THIRD PARTY OBSERVATION – SID APPLICATION CASE REF. 324113

Cashla Peaker Plant, Rathmorrissy and Pollnagroagh, Athenry, Co. Galway

Case Reference: SID Application 324113

1 TYPICAL SECTION STREET
Scale at A1 1:20
Scale at A3 1:40

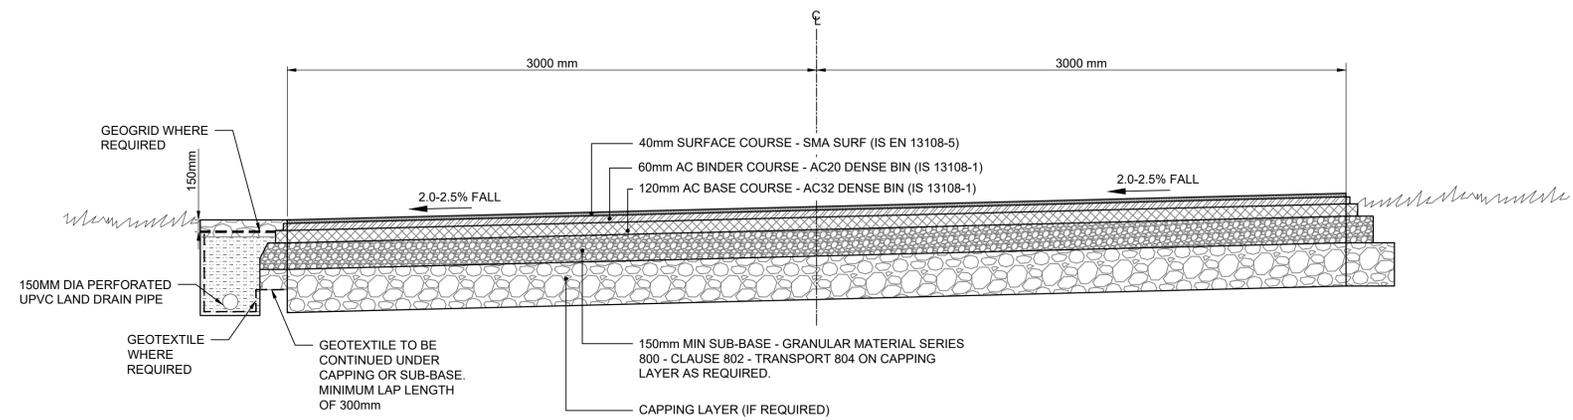
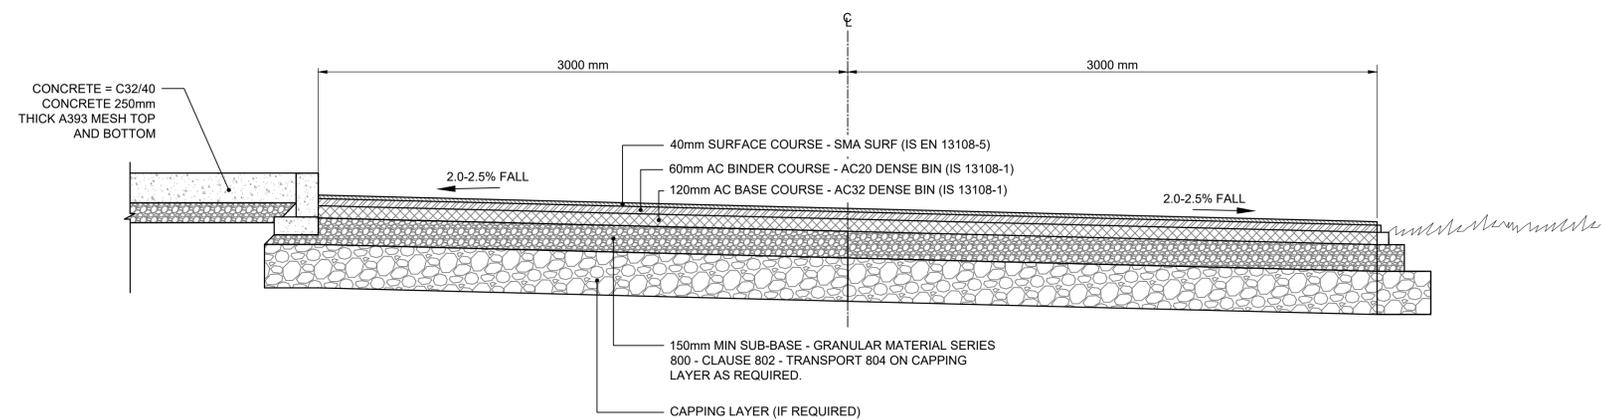
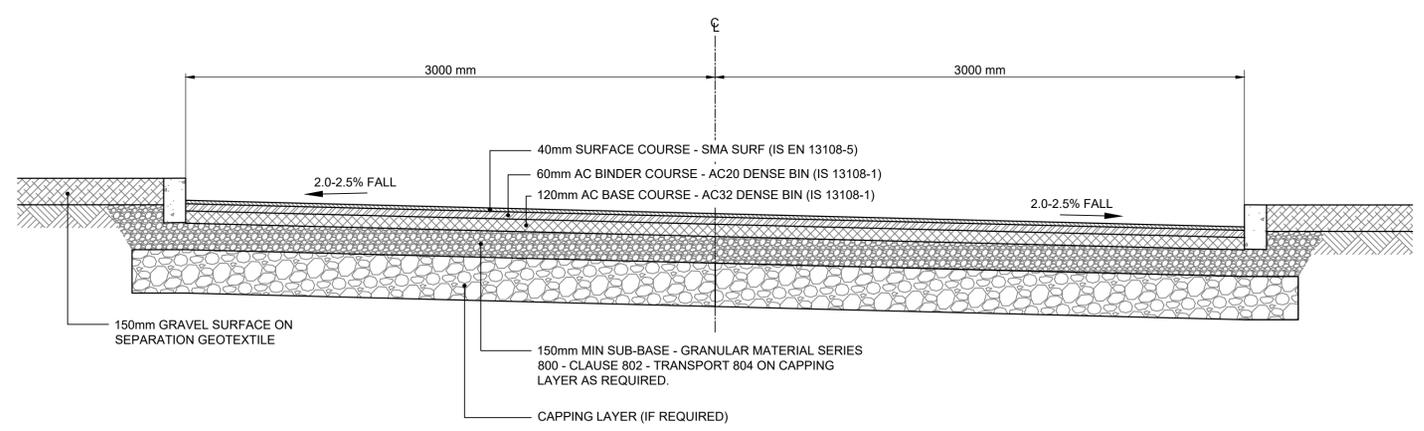
A 2.5 metre carriageway is the width of a parking space. This is what remains for our car, school buses, tractors, and emergency vehicles during cable installation. The EIAR classifies this as “negative, moderate and short term.” We travel this road four times a day with our children.

Purpose		PLANNING			
Title		SITE ACCESS SIGHTLINES			
Original Scale	Design/Drawn	Checked	Authorised		
SHOWN at A1	PS	ND	AJB		
Date	Date	Date	Date		
01.12.25	01.12.25	01.12.25	01.12.25		
Status	Drawing Number	Rev			
A2	PEK3-ATK-ZZ-01-DR-CE-901200	0

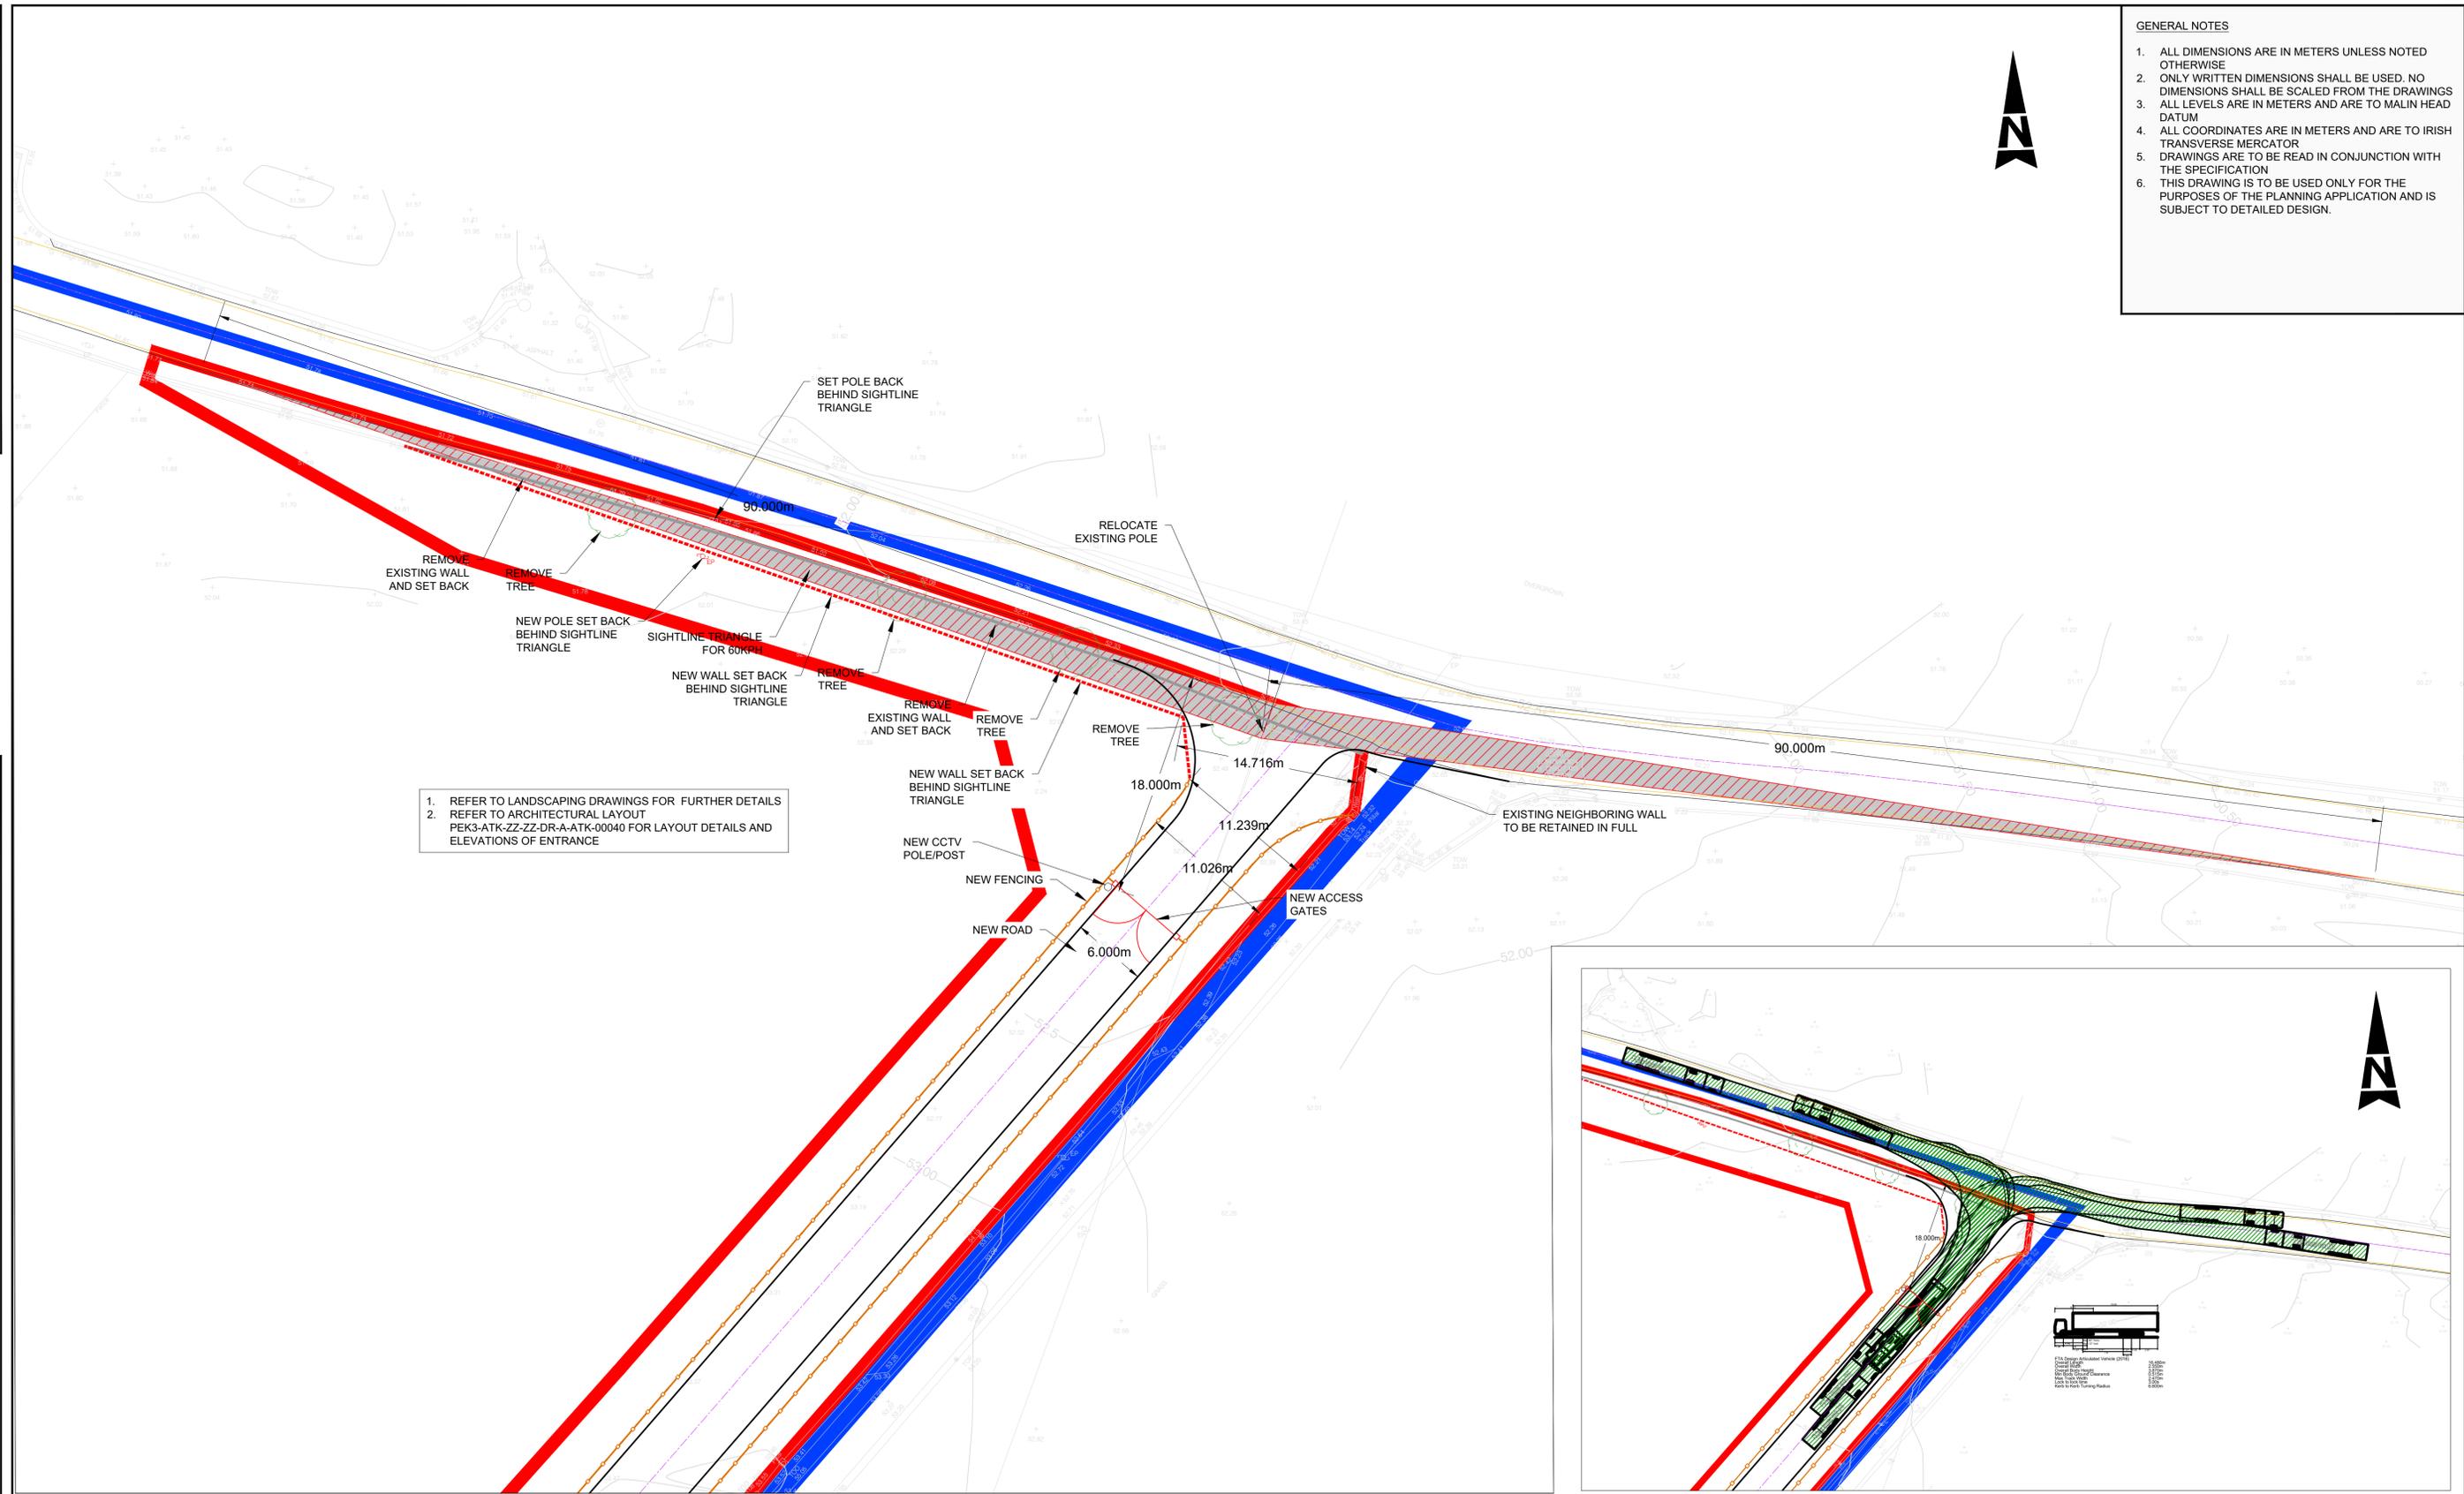
The proposed site entrance is on this road. Every HGV, worker vehicle, and abnormal load for 25 years enters and exits through a junction on the road our family uses four times a day. From looking at the autotrack drawing for HGV's, it is clear that they can not make this turn safely without crossing into oncoming traffic to make the turn need to enter and exit the development. This is an unmeasurable road hazard and will put the lives of everyone else in danger everyday and we can not let this be granted.

Applicants drawing PEK3-ATK-ZZ-01-DR-CE-901200, Autotrack for HGV at the entrance, all four turning accesses laid on top of each other which makes the drawing confusing and extremely difficult to read

The continuous white line on the L3103 is there because the county council judged the road too narrow for safe two-way traffic at speed. Every HGV turning in or out of the proposed site entrance creates a conflict that the road markings themselves warn is dangerous. The EIAR ignores this.

Drawing file: MEP / PEK3-ATK-ZZ-ZZ-DR-EE-901300 Proposed Site Lighting Layout.pdf

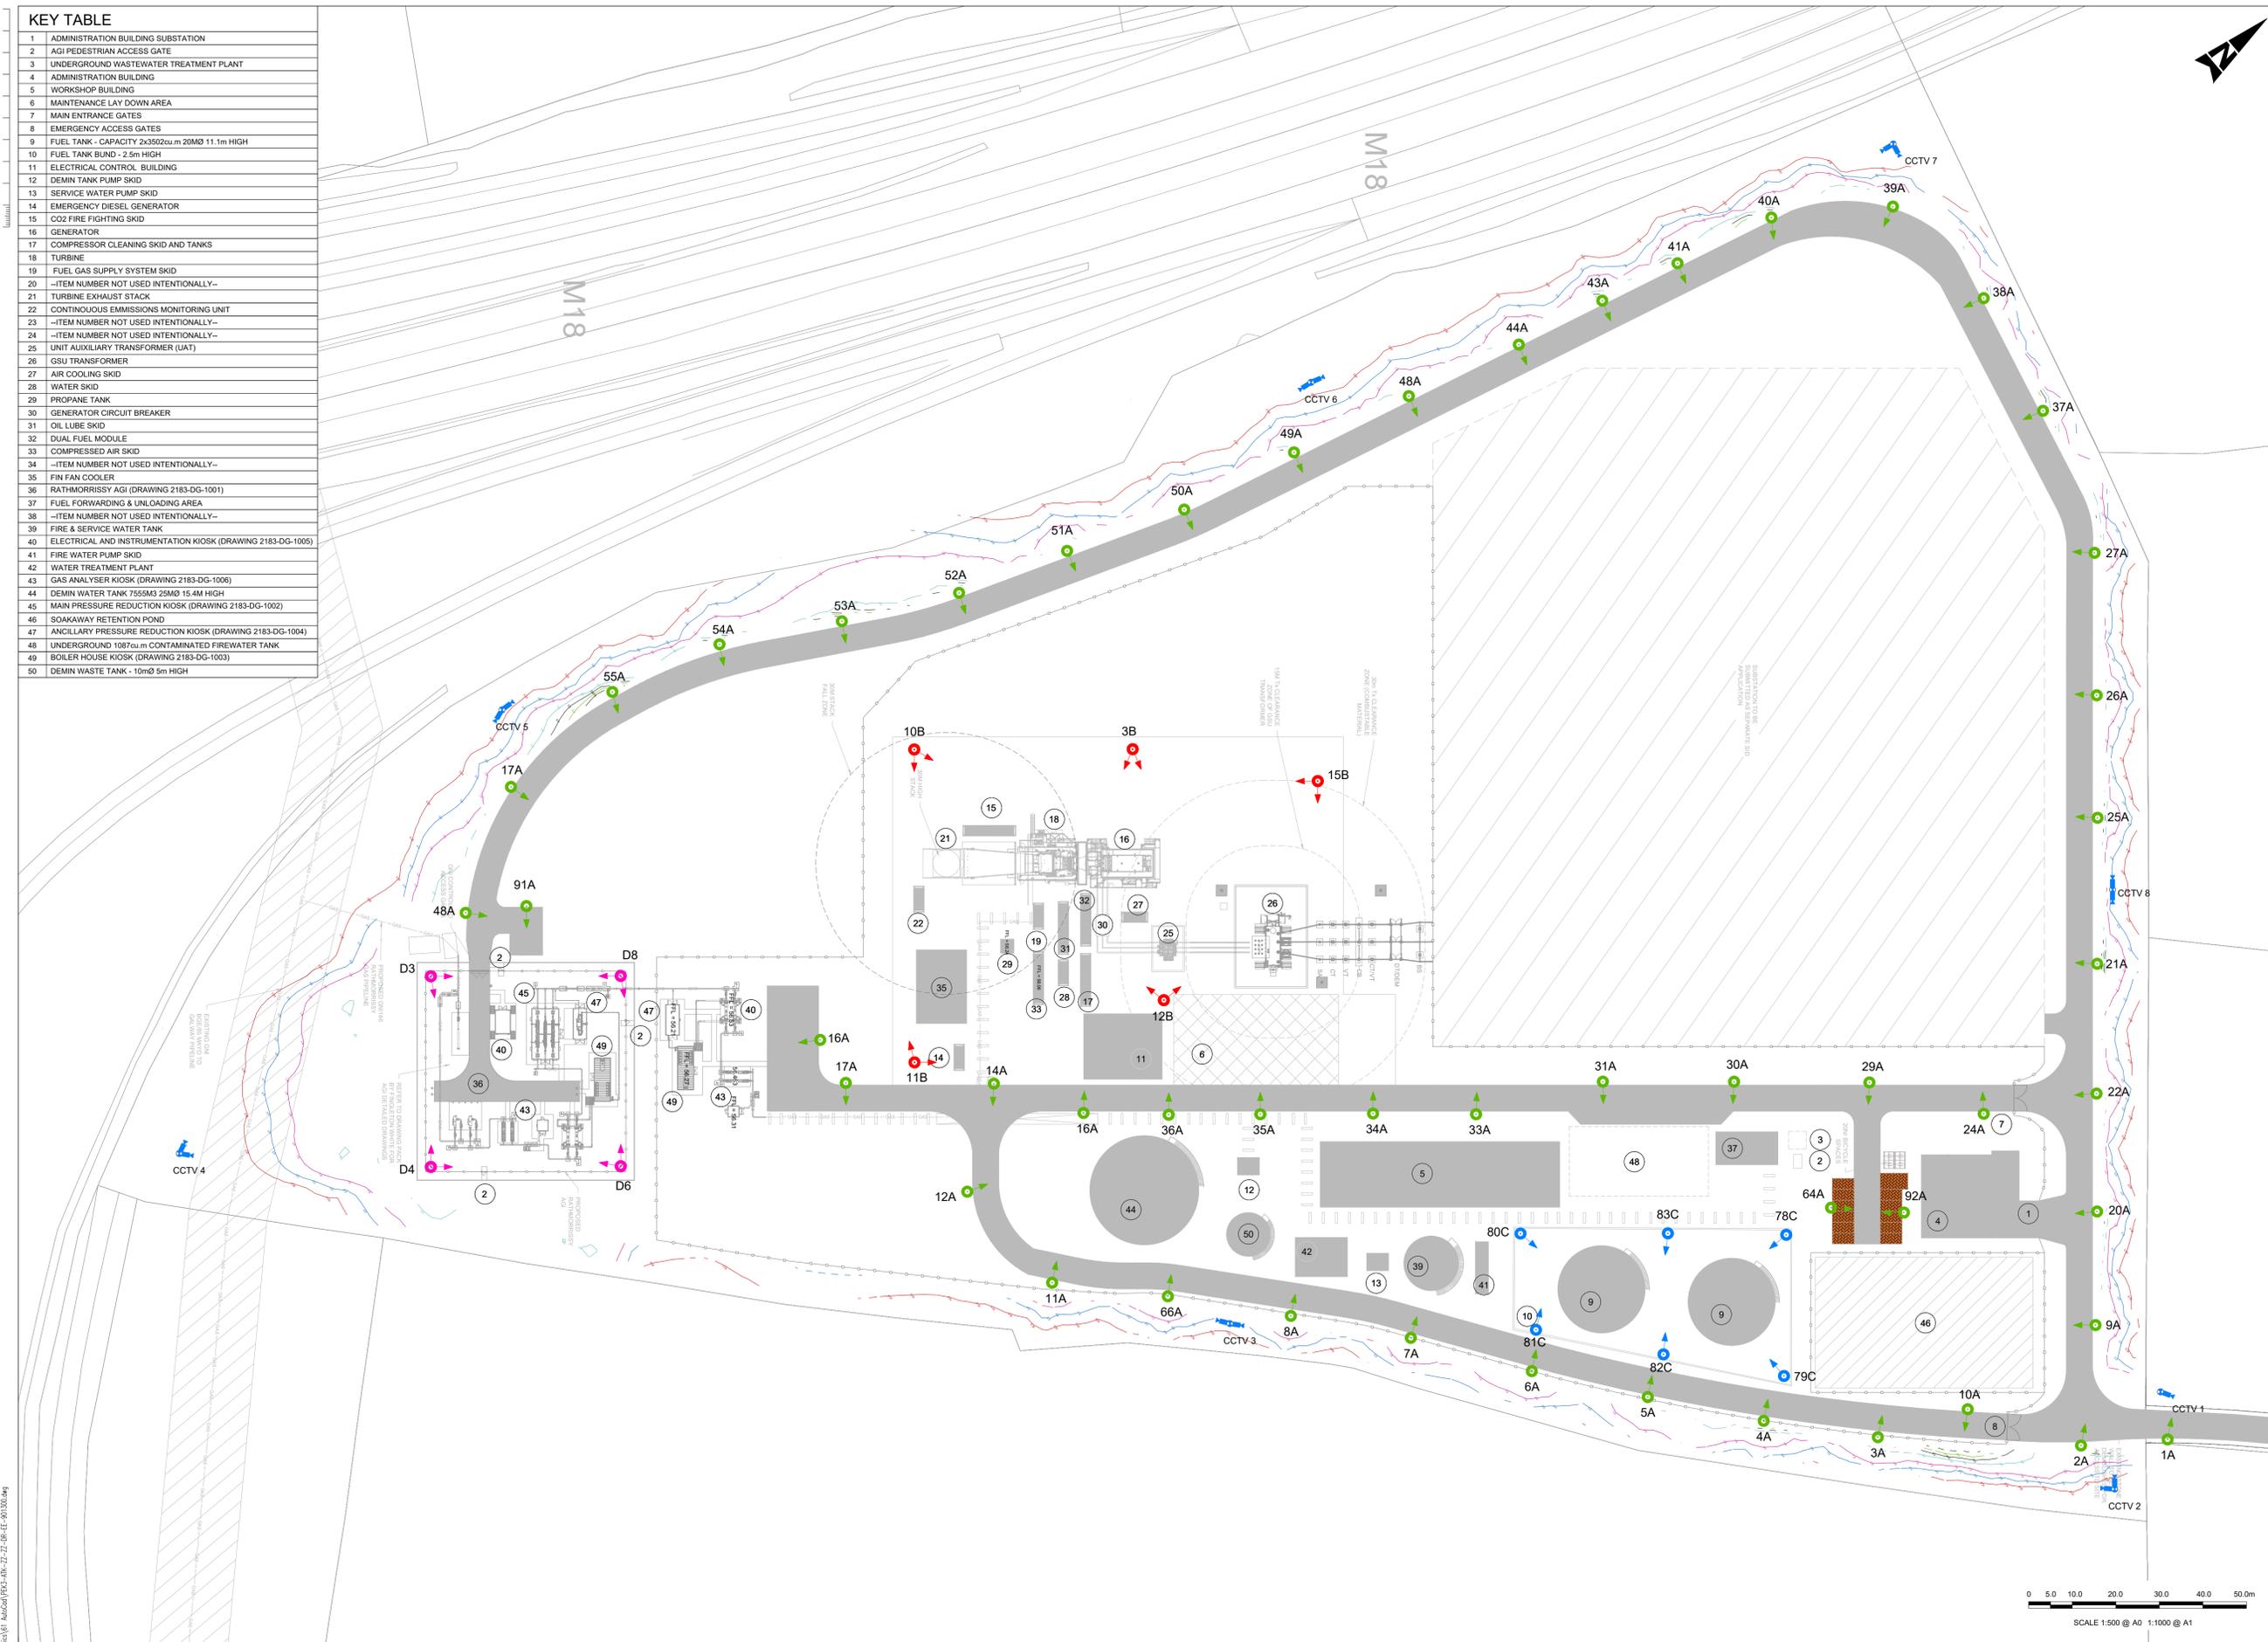
The proposed development includes 20-metre high LED lighting masts with operational and security lighting on a 24-hour basis. The applicant’s own site lighting report details the installation of multiple high-intensity LED masts. Castlelambert is currently a dark rural landscape. On a clear night we can see stars from our garden. Our children know what a dark sky looks like. The introduction of 20-metre industrial lighting masts 670 metres from our home will permanently alter that.

- The south-eastern treeline boundary – recording 3,760 bat calls – functions as a dark commuting corridor between the agricultural landscape and foraging areas. Twenty-metre LED masts alongside this corridor will create what the literature describes as a “**photic wall**” – a barrier of light that bats cannot cross. Their established commuting routes, used for generations, will be severed
- Swallows, House Martins, and Sand Martins are **crepuscular feeders** – most active at dawn and dusk. Artificial light extending and distorting the effective length of the day

- Galway County Development Plan **Policy LP 1** requires that lighting schemes minimise excessive light spillage and limit light pollution to residential amenity and wildlife. **No night-time visualisations have been provided.** No assessment of the lighting scheme's impact on the wildlife corridors and habitats confirmed by the applicant's own ecological surveys has been conducted. Compliance with LP 1 has not been demonstrated.
